Our Ref: 2023/520926
File No: R/2022/24/A

SSD-32275057 – Redfern Mixed Use Co-living Development – Advice on RtS

Thank you for your correspondence dated 18 August 2023 inviting the City of Sydney Council ("the City") to comment on the Response to Submissions (RtS) provided for the proposed State Significant Development (SSD) application for a new co-living housing development at 175-177 Cleveland Street, 1-5 and 6-8 Woodburn Street, Redfern.

TYPICAL CROSS-SECTION [A - A]
through ON-SLAB PLANTER

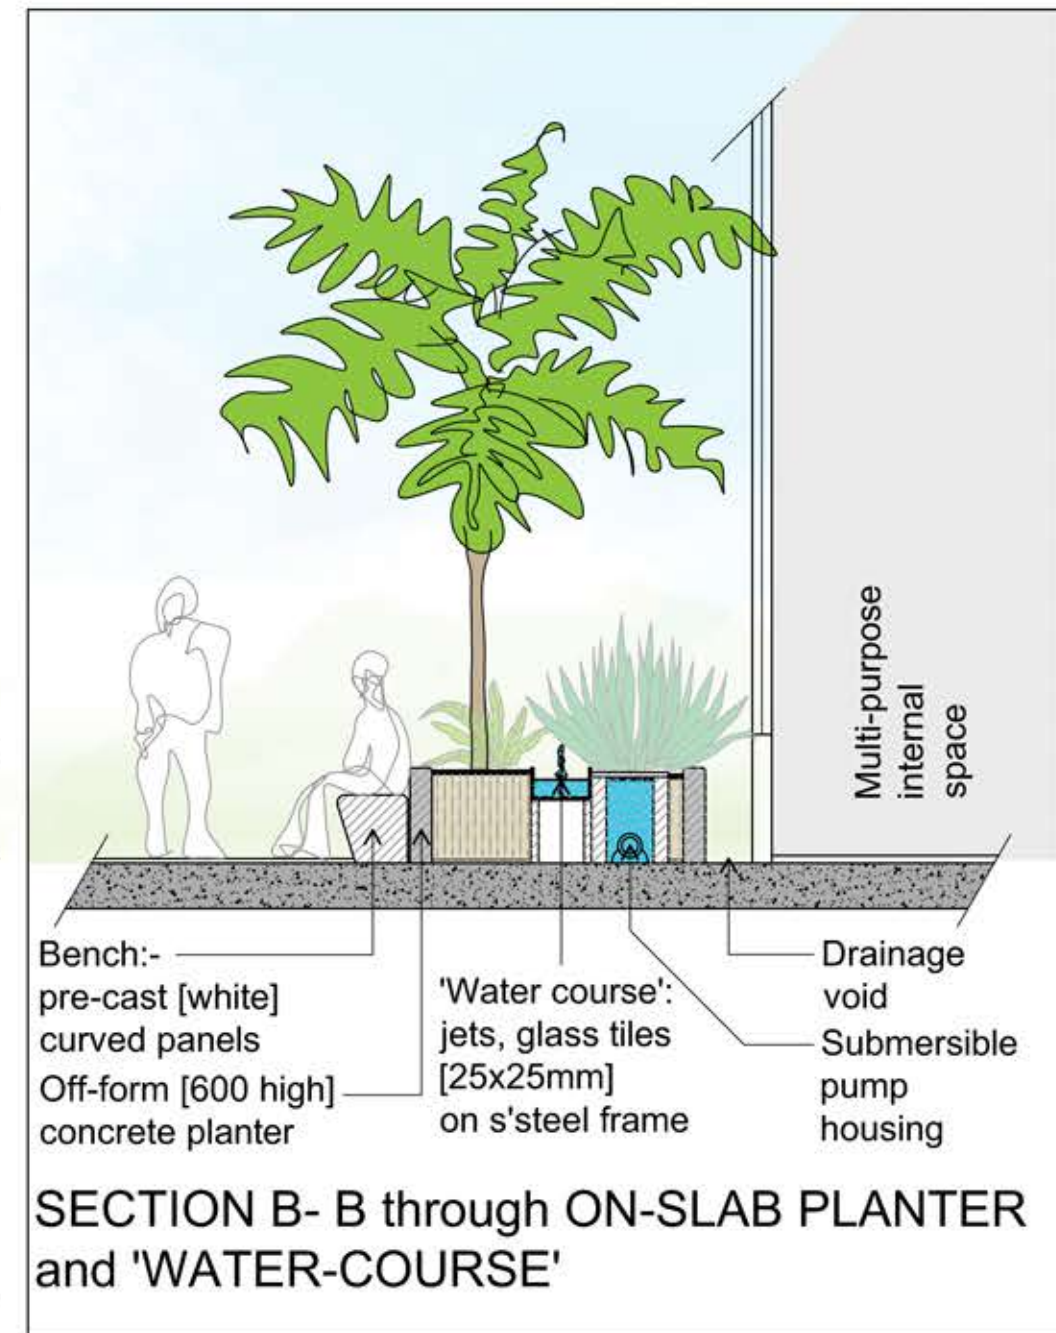
With regard to deep soil, the landscape plans have been updated to show the small courtyard areas to the south-east as deep soil, with a total of 39.2sqm or 3.6% of the total site area provided. The design of the deep soil zones includes rigid concrete pavement on slab, a planter with 4 small-sized trees and a narrow planter with 1 small sized tree. This small tree in the narrow planter will be wedged between the basement wall and area of rigid pavement that leads to a blank wall, and is also impeded by the

building that projects over. It is recommended that this planter be amended to increase the garden area to support the growth of a tree to maturity (perhaps with a planter design that lines up with the wall dividing the laundry and bin room).

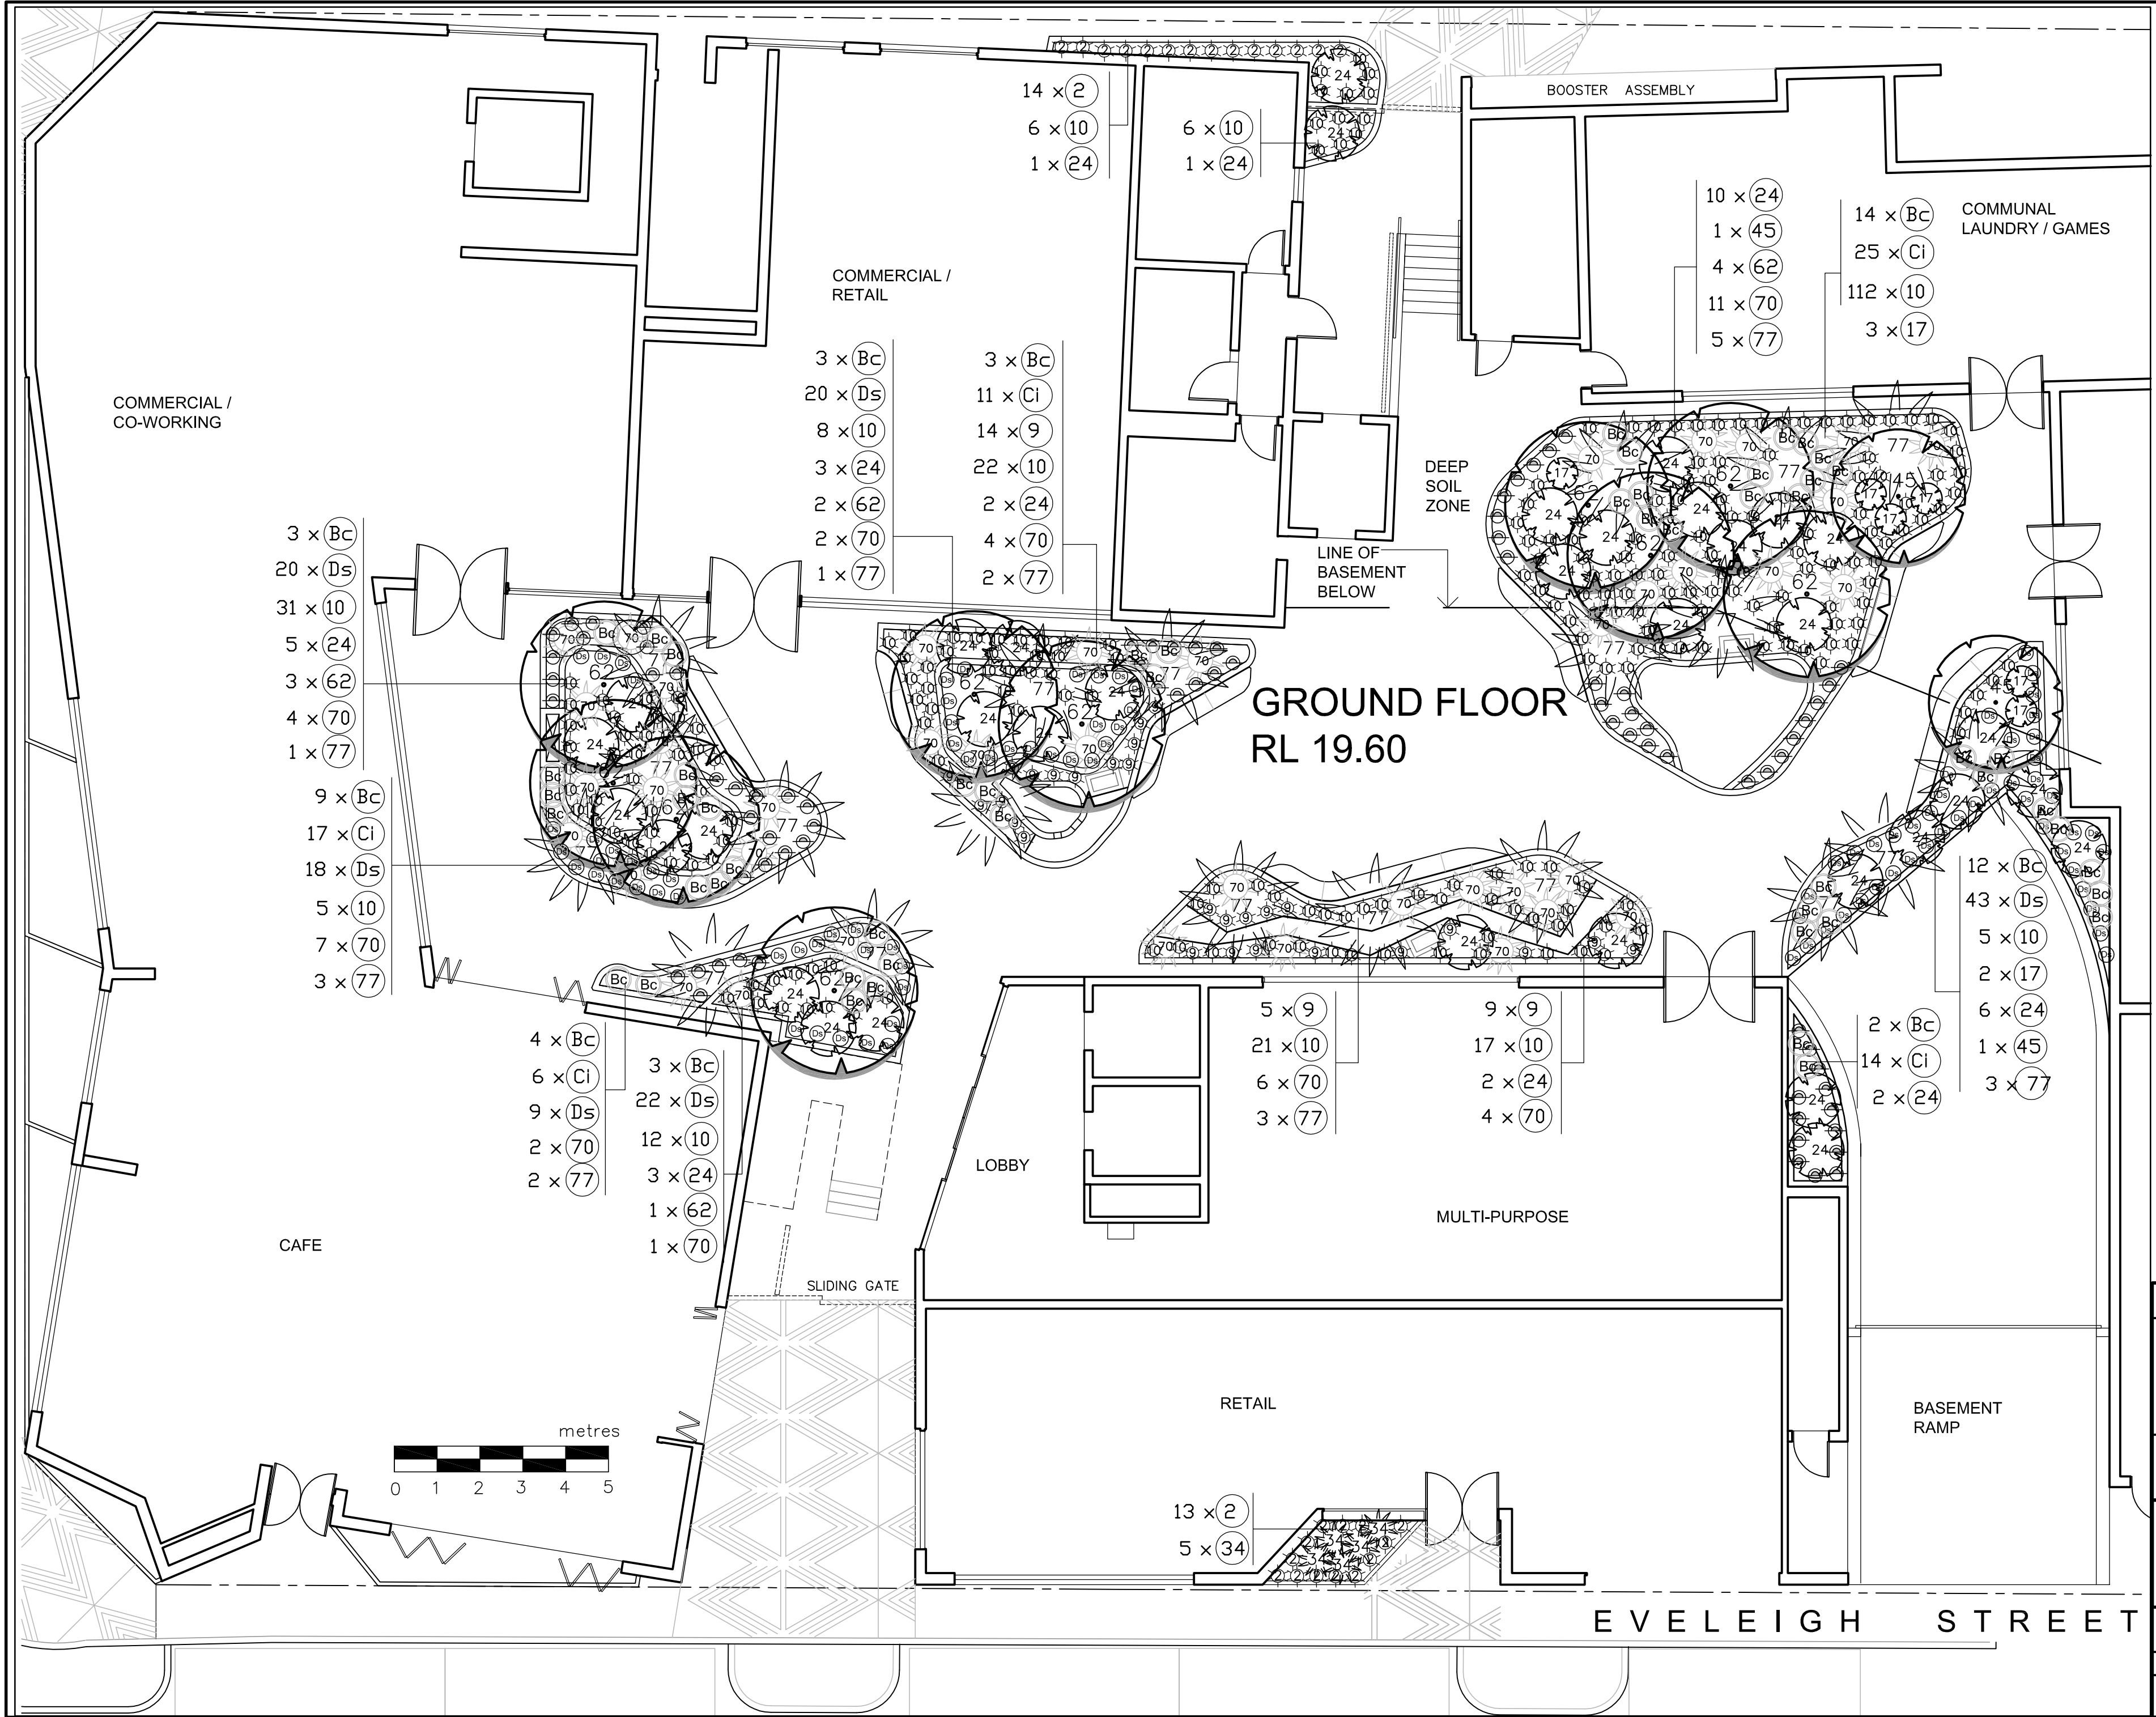
- Ground floor –
 - The proposed raised planter design limits available soil for tree root balls to establish and thrive to maturity. It is recommended that this planter design be amended to delete the corten steel raised edging and provide a 1m high planter wall.

- Absent clarity remains for how the water feature design can prevent any children climbing in. To comply with the regulations, please amend the design to reduce the water depth to mitigate the risk (noting that a depth of 30cm or more requires fencing).

PROJECT No.: 20:12:3	DRAWING No.: PP_L5
SCALE: 1:100 @ A2	ISSUE: B
DRAWING Planting Plan: Level 5

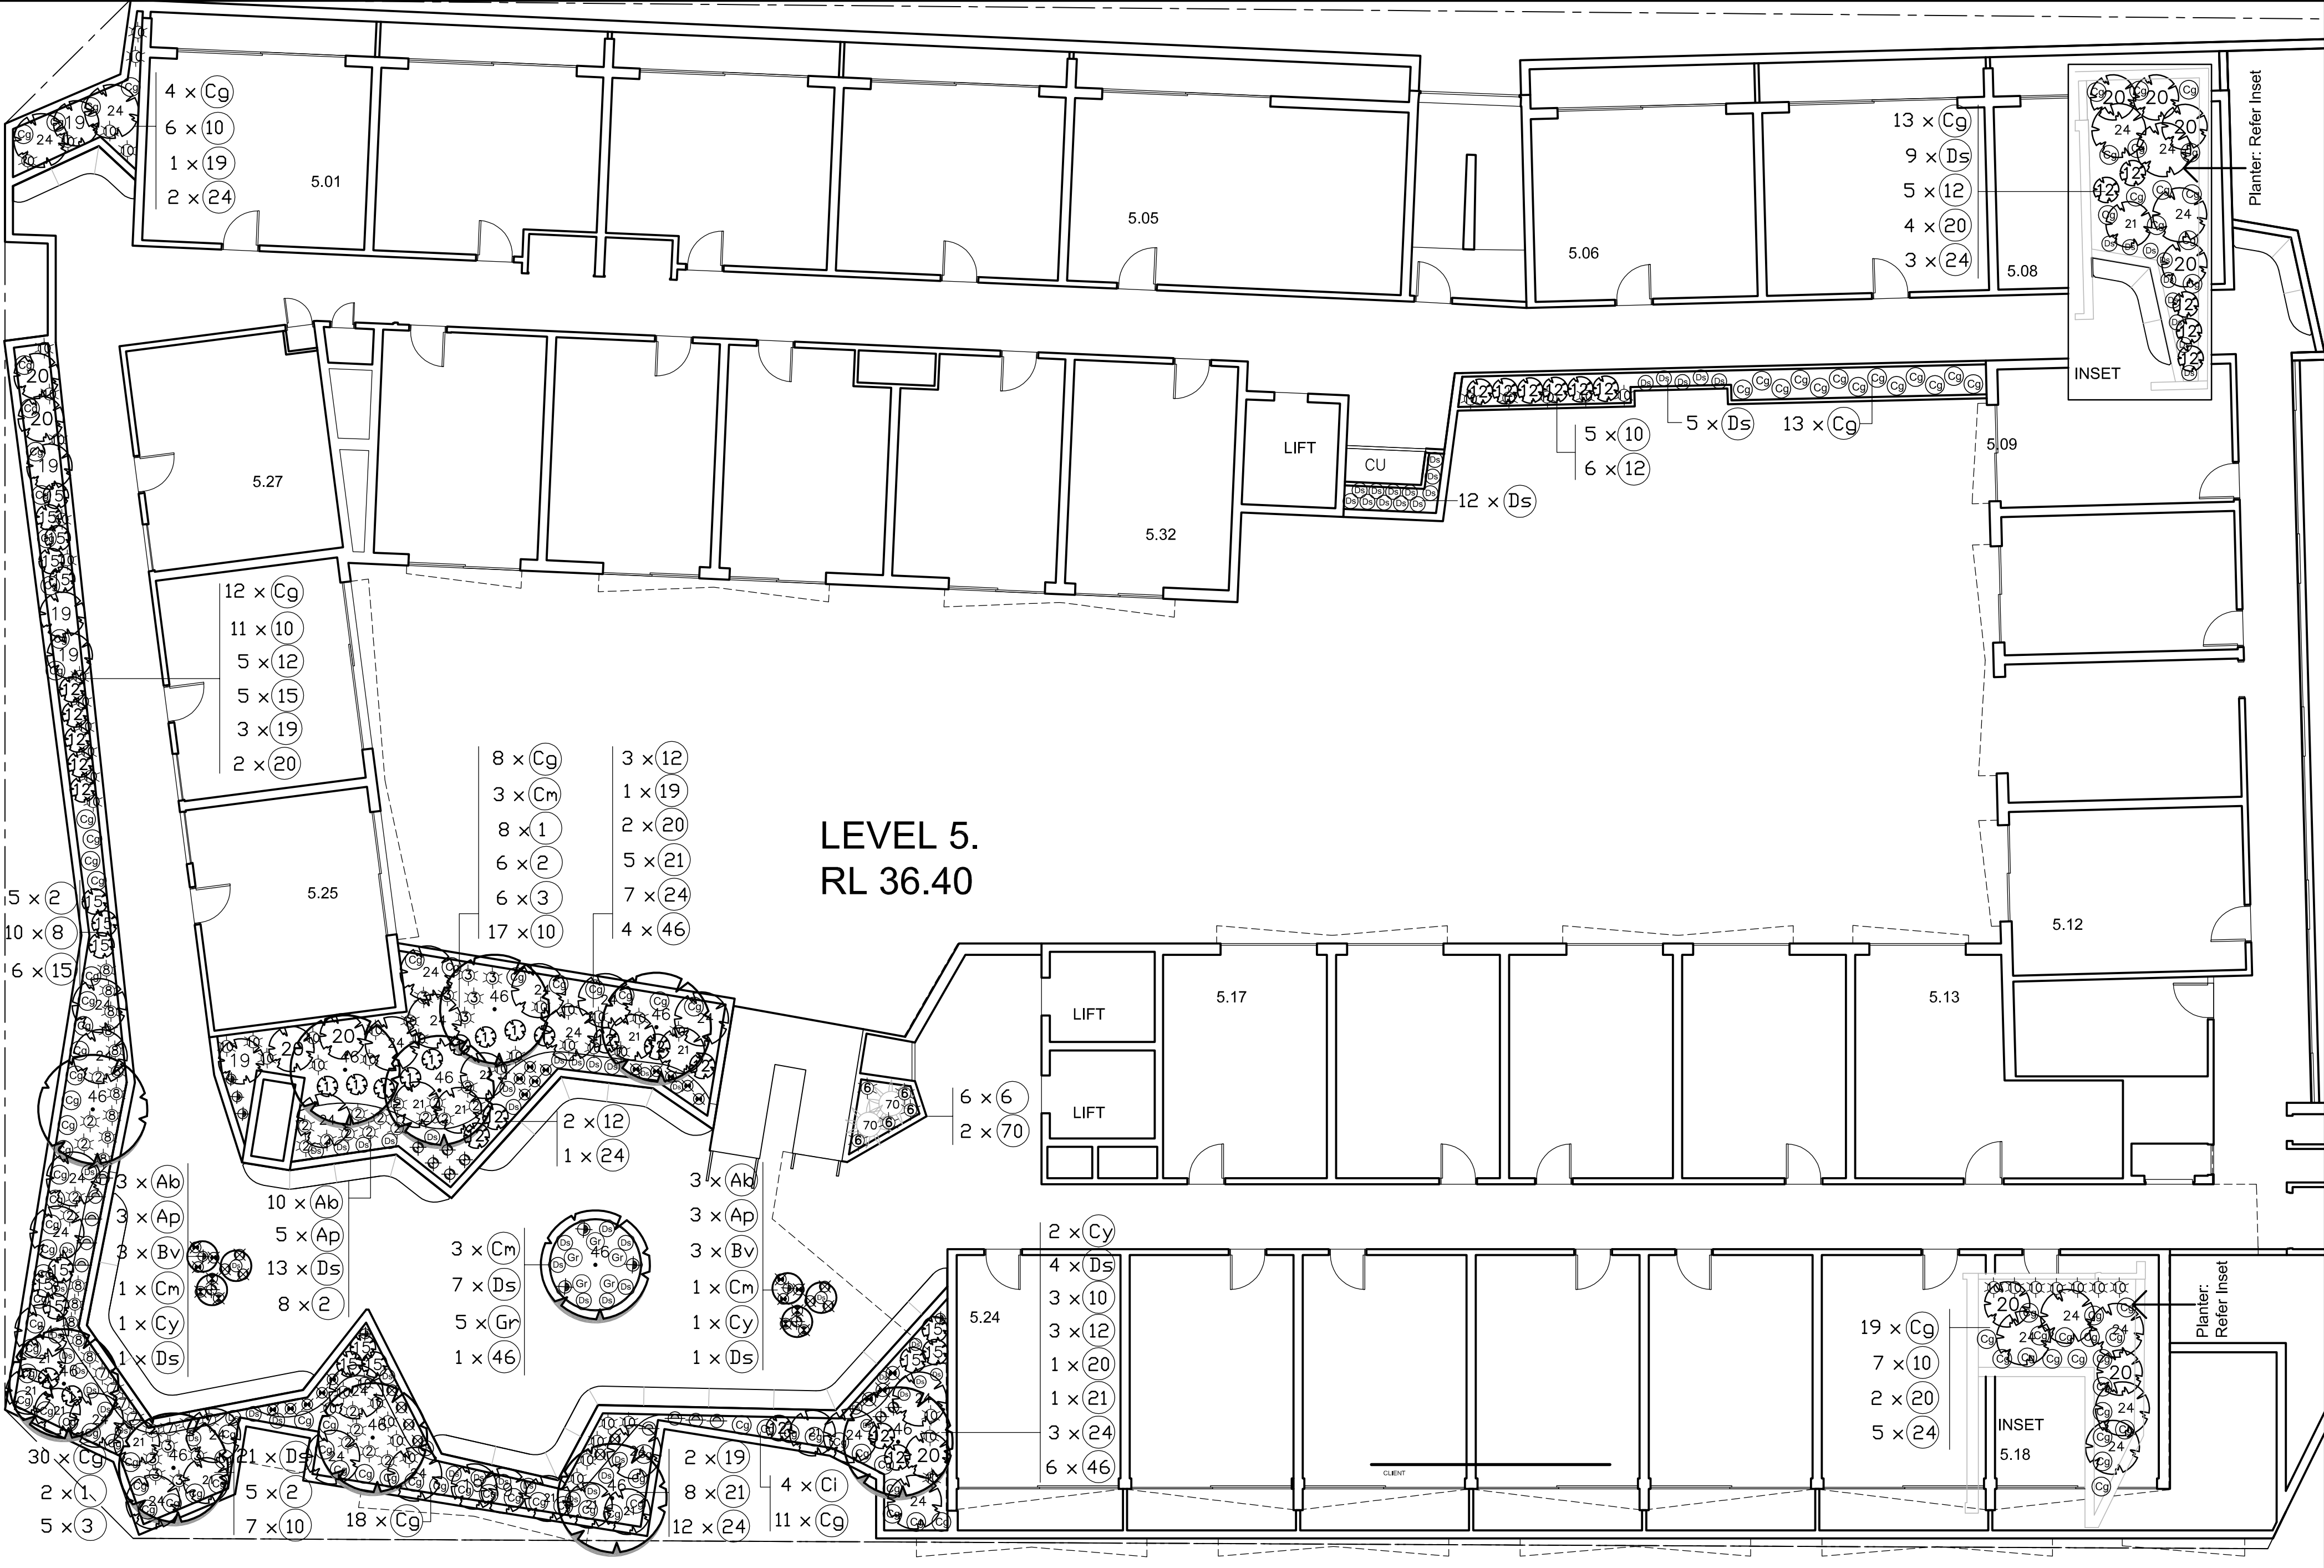
- Level 5 –
 - A cantilevered shade structure to future detail is proposed within a raised tree planter over one bench seat. The shade structure remains small, attached to a low wall on the eastern edge that is unlikely to provide adequate shade for residents.

- The design ideas to connect with country and provide a dance space is supported, however, it must be designed with suitable surface finishes, raised planters that can support shade trees to mitigate site impacts. Residential amenity impacts facing Cleveland Street and due west will be a hot, noisy, wind swept roof terrace. Use of gravel pebbles and concrete pavement near seating areas on the western edge of the terrace will exacerbate heat impacts and make this a hostile space. The design and surface materials must be reviewed to limit heat and increase areas of natural shade.

- A new communal lounge with kitchen is proposed in the northeastern corner, which includes a narrow outdoor terrace to the east. There is a narrow dead space between the kitchen blank wall and the terrace edge that will be too narrow to gather and will collect rubbish. This space would be better redesigned as an inaccessible raised planter to fill the gap.
